2026/90441 Huddersfield Bus Station

BWB Environmental Health Response (WK202605229)

Project Name:	Huddersfield Bus Station, Canopy Development
Project No:	221692
Revision:	P01
Author:	Luke Cross
Approver:	Tim Hull

P2 Proposed Bin Store Plan  
Scale: 1 : 50

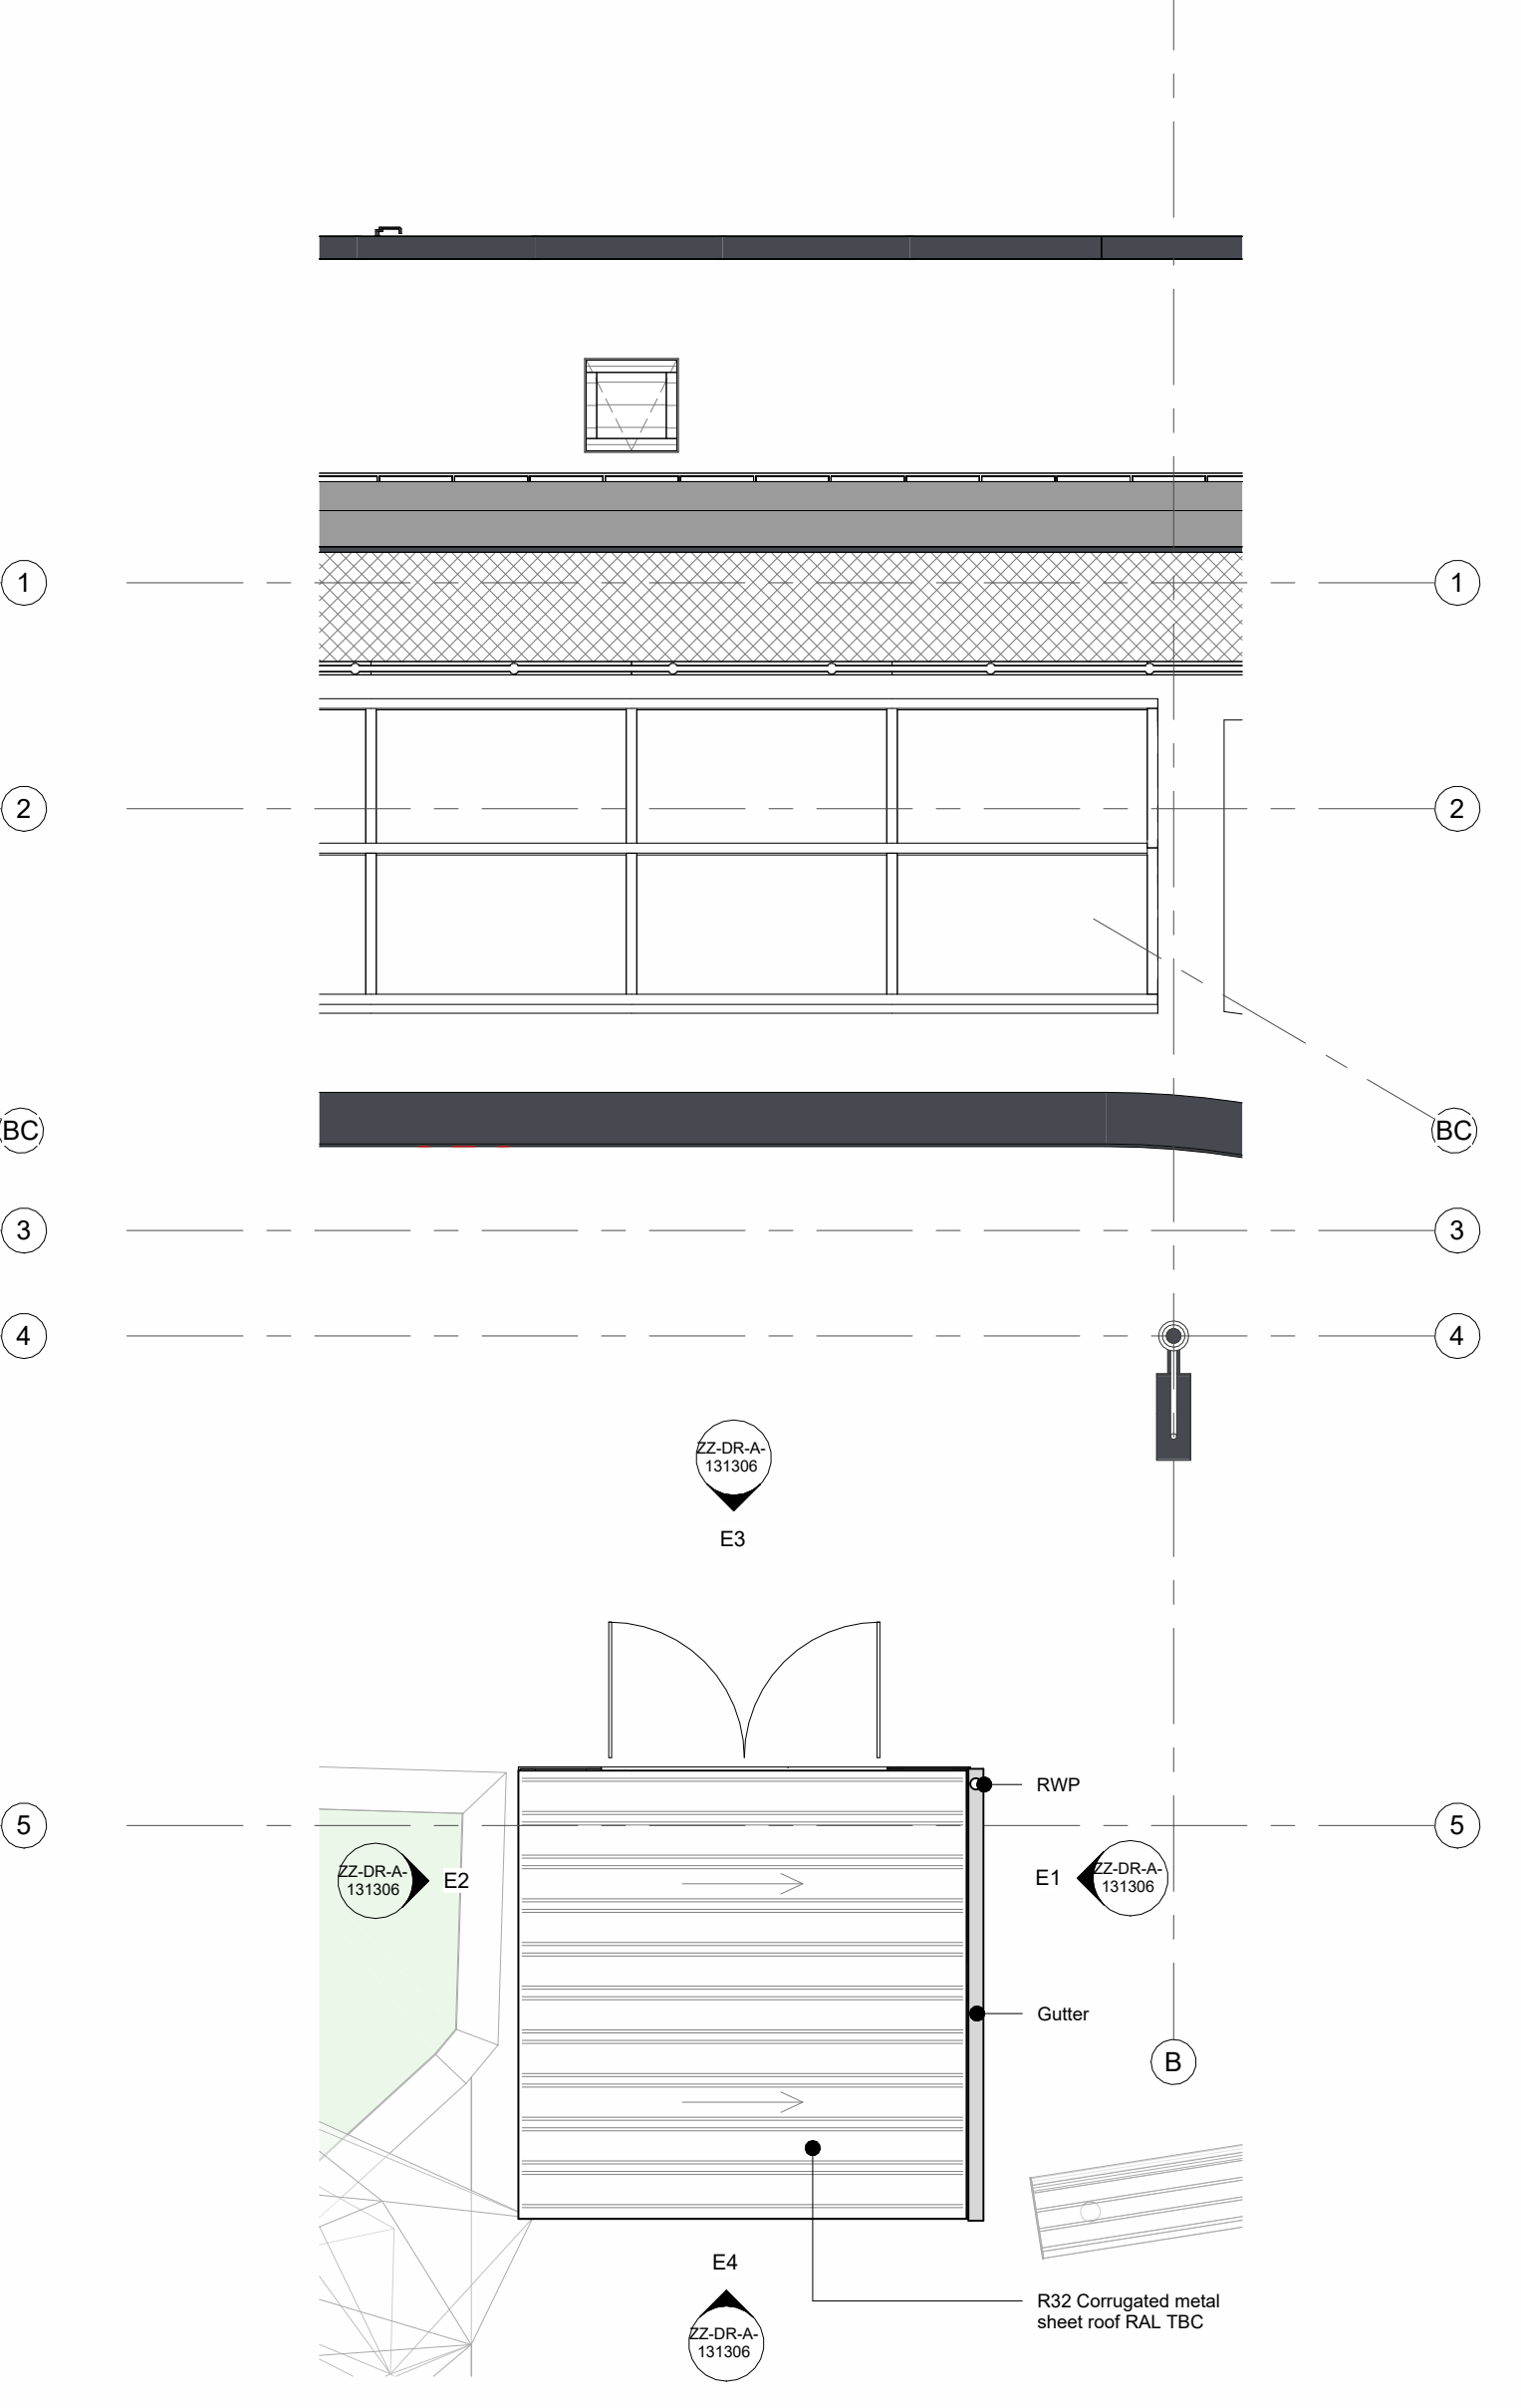
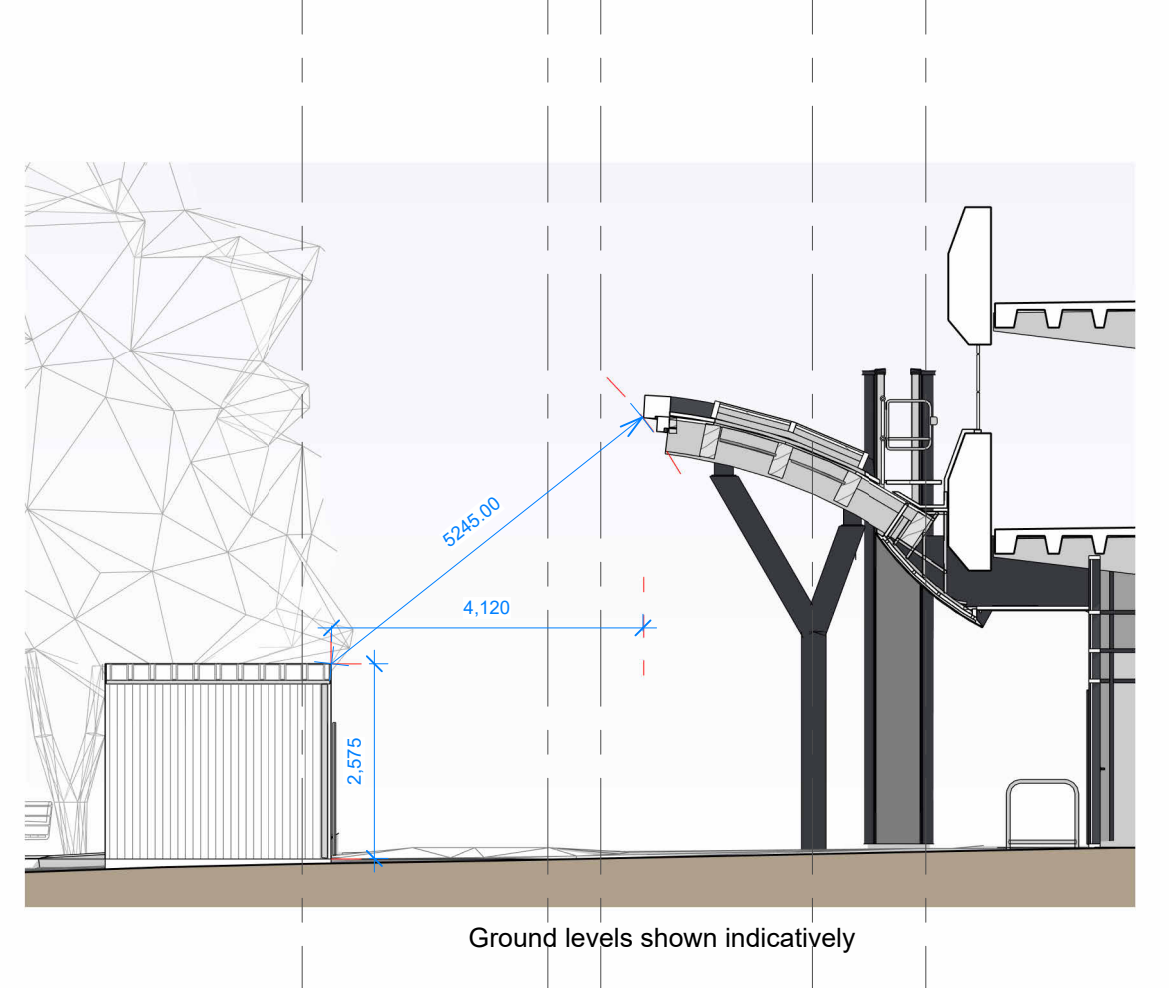
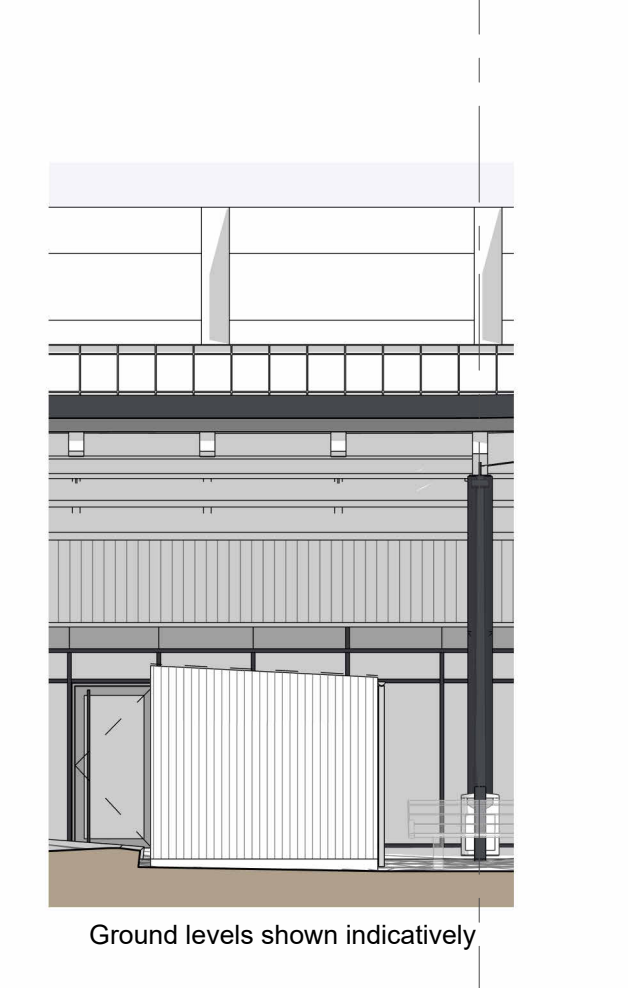
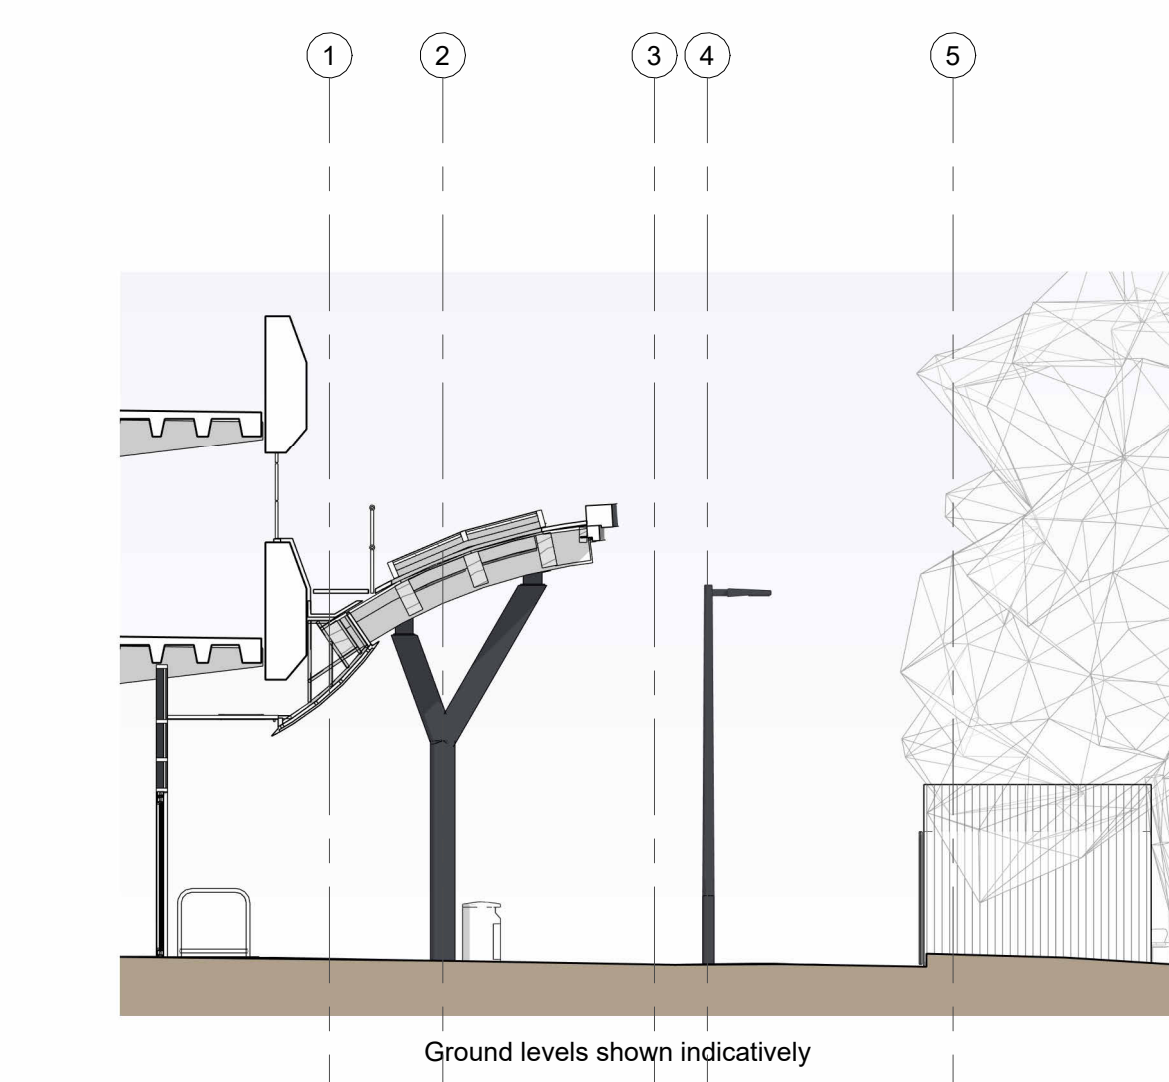
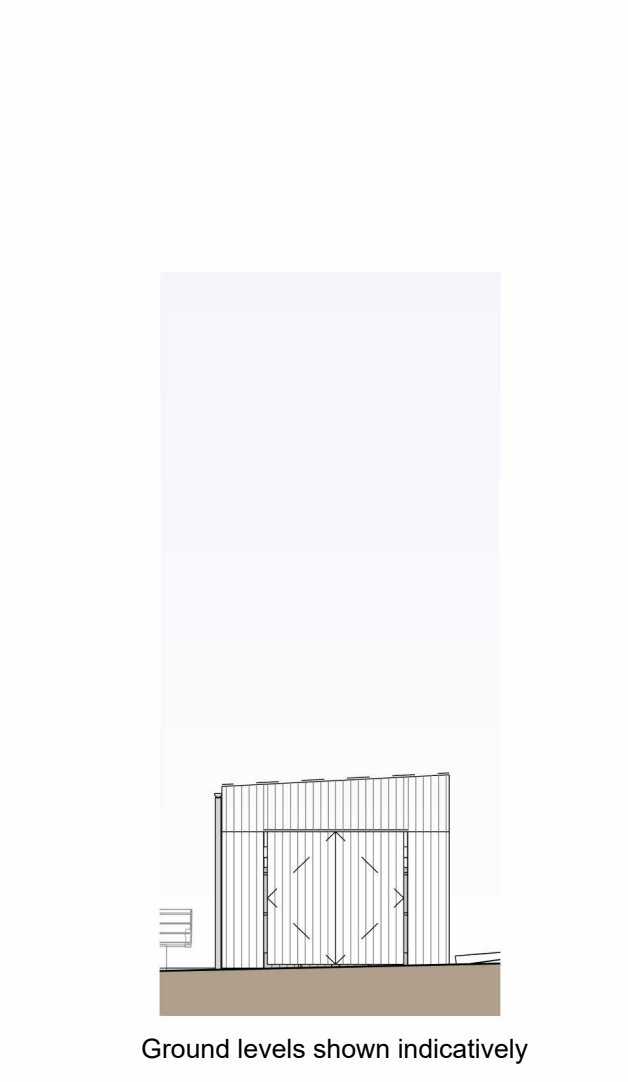
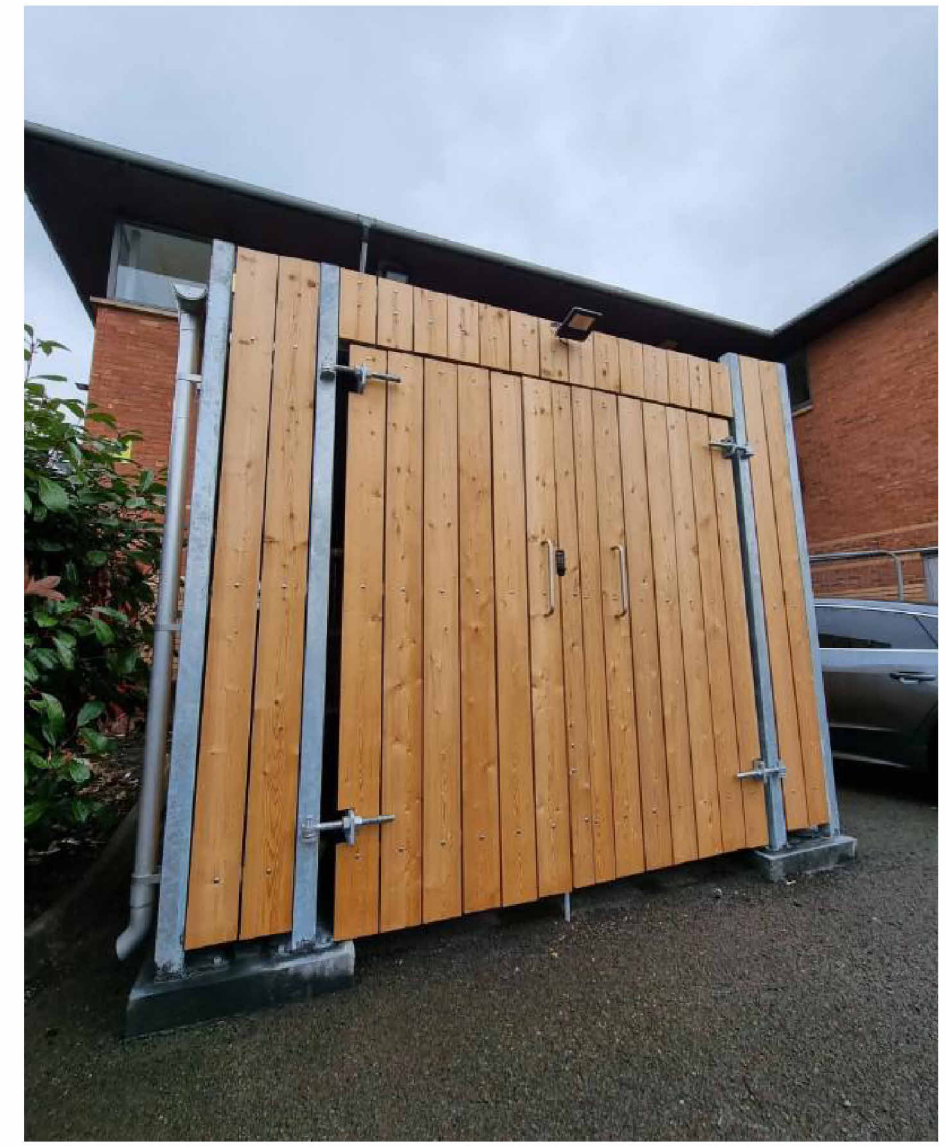
The development comprises a canopy structure that is open on three sides. A bin store is also proposed in the southern part of the application area and will be the only structure at ground level. Based on drawing 20235-SGP-ZZ-ZZ-DR-A-131306, dated 10/12/23, the bin store will incorporate a clear gap between ground level and the base of the walls, together with a second gap between the top of the walls and the roof structure. It is therefore not considered to form an enclosed space requiring gas assessment in accordance with CIRIA C665 and BS 8485 guidance.

Given the nature of the proposed development, BWB considers it appropriate to limit the number of ground gas monitoring visits to two and concludes that no ground gas protection measures are required.
